From: Carol Reynolds <Carol.Reynolds@arun.gov.uk>
Sent: 17 November 2021 15:31
To: Michael Eastham <Michael.Eastham@arun.gov.uk>
Subject: FW: LU/206/21/RES - PHASE 5, HAMPTON PARK
Importance: High

Environmental Health : I refer to the attached Tetra Tech Noise Assessment, 784-B028030, April 2021. The figures provided in Tables B1&2, Appendix B show that BS:8233 guidelines cannot be achieved in habitable rooms with windows open. The ProPG states that design layout should be optimised so that habitable rooms are oriented away from sources of adverse noise. I have looked at the layout of sample house types along the road which demonstrate that habitable rooms, including bedrooms in roofs, could be reorientated to face away from the predominant source of noise ie the road. Arun Planning

Figure 5.1 Glazing and Ventilation Strategy

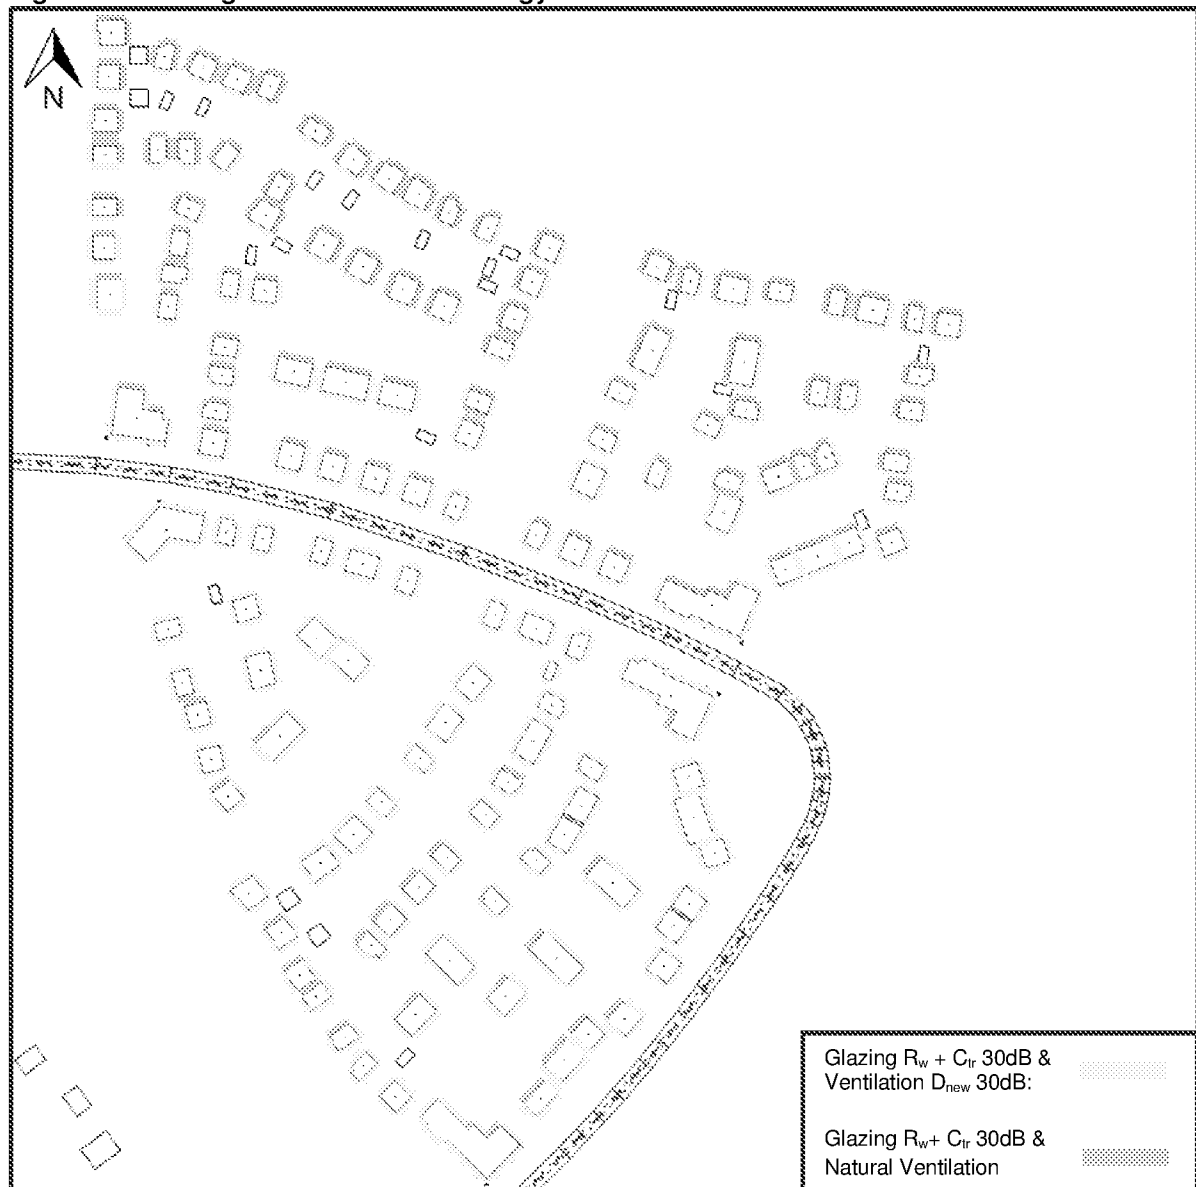
In this case, mechanical means of acoustically treated artificial ventilation should be provided to all adversely effected houses and flats, so that future occupants will have the option of controlling thermal comfort with the windows closed. Such a system should be based on based on MEV3 or 4 as detailed in the Building Regulations, Approved Document F. Whereas the report mentions that mechanical ventilation may be required, this is excluded from Fig 5, Glazing and Ventilation Strategy which only details proposed glazing and passive ventilation.
